Planning Inspectorate Reference: EN010098
MMO Reference: DCO/2018/00014
Identification Number: 20029896

Planning Act 2008 - Application by Ørsted Hornsea Project Four (UK) Limited (“Ltd”) for an Order Granting Development Consent for Hornsea Project Four Offshore Wind Farm

Deadline 5 Submission

Figure 3: 1979 and 2011 bathymetries of Smithic Bank (top and middle) and a comparison of the 1979 and 2011 bathymetries (bottom).

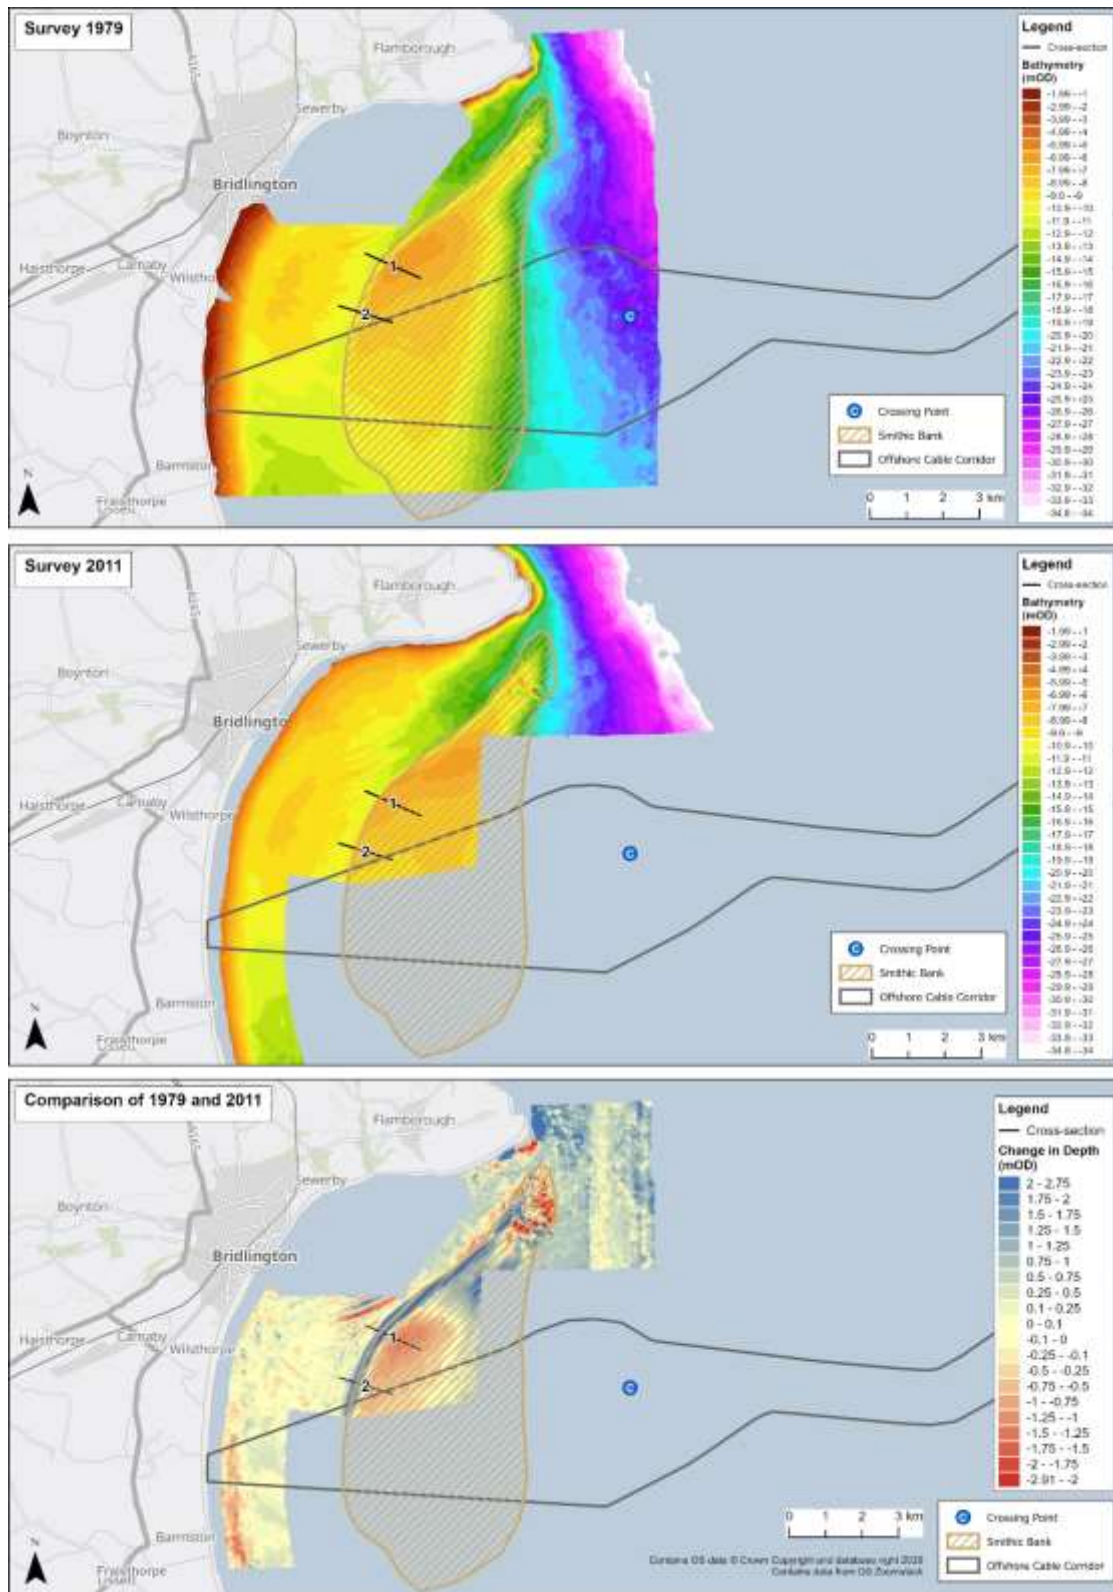
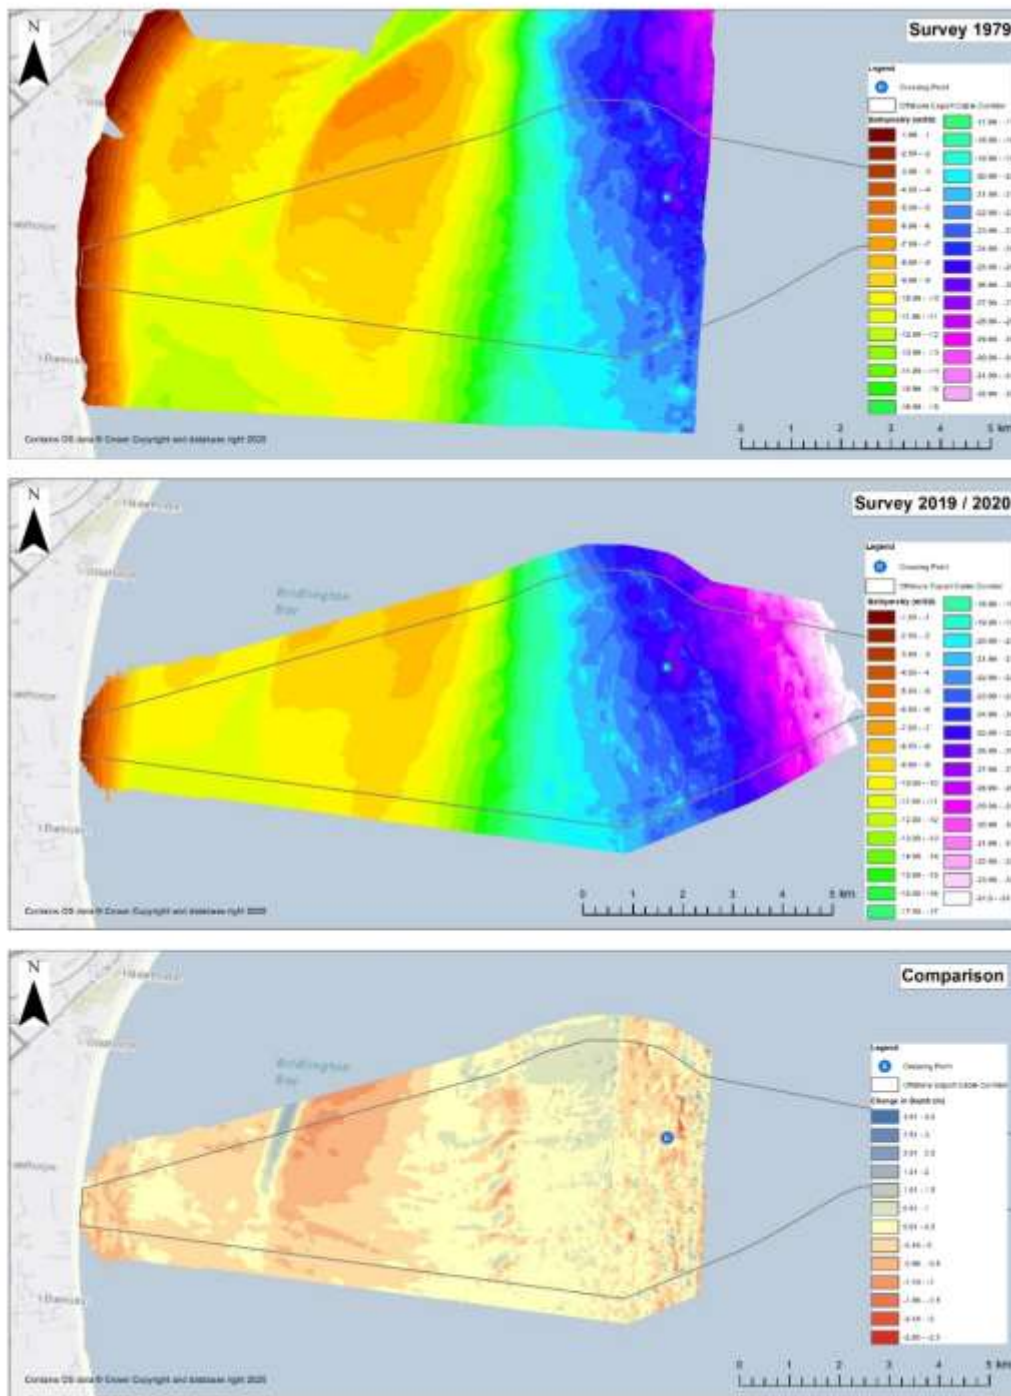
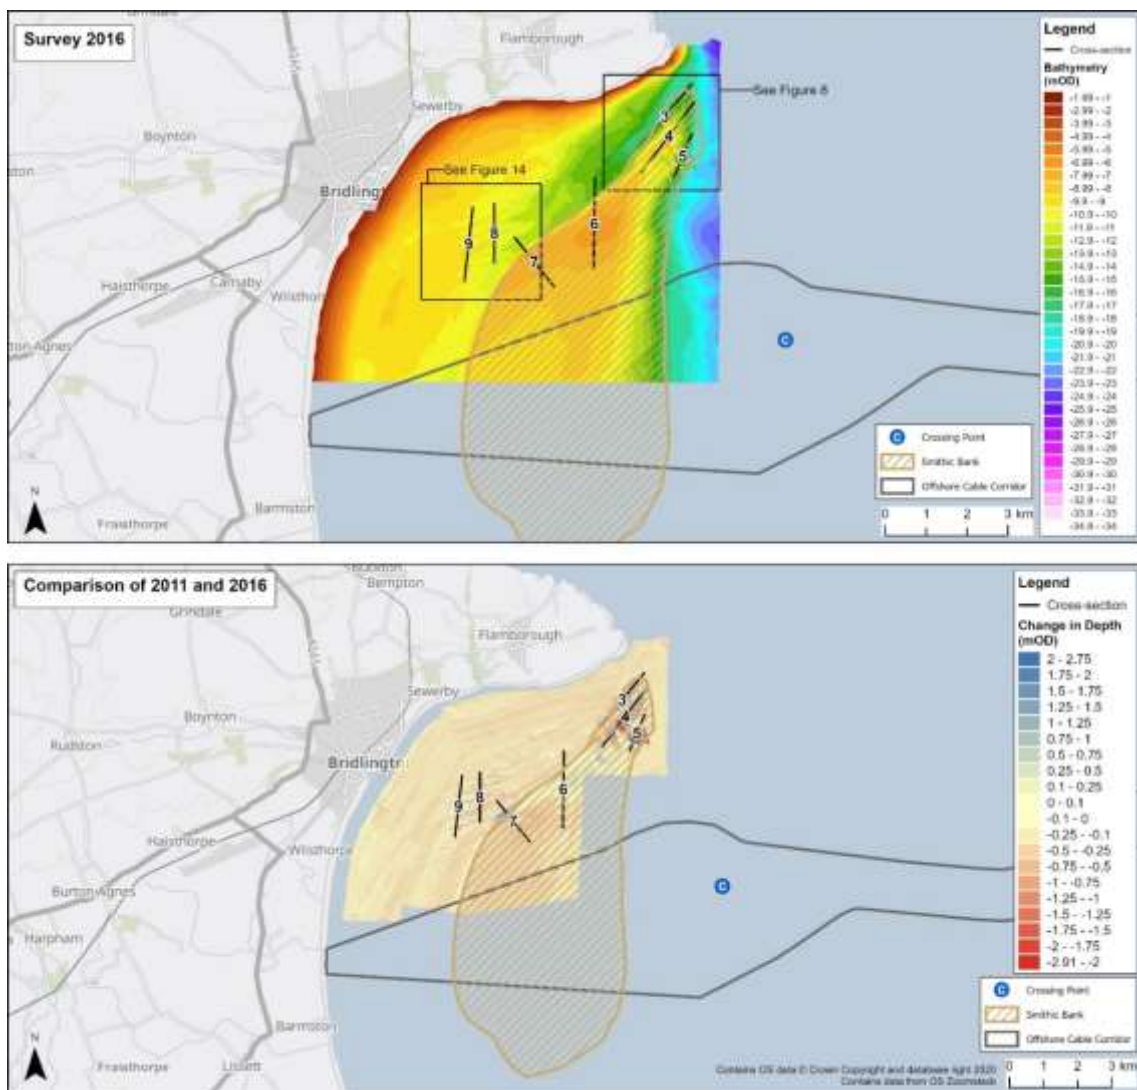
4.1.3. Smithic sand bank

The Applicant has chosen to use an EGA (Expert Geomorphological Assessment) to determine the degree of impact of the cables. Whilst this process is relatively new and to our understanding no formal guidance on the methodology are available, it has been used successfully in a number of high-profile projects that are of national significance. Our understanding of an EGA is where a number of recognised experts are brought together who have diverging points of view. Over the course of a few days, the strength of the evidence is tested, and a number of agreed scenarios developed. The strength of the process is that opposing views have been brought to a consensus. In this document the adherence to this general procedure is not documented.
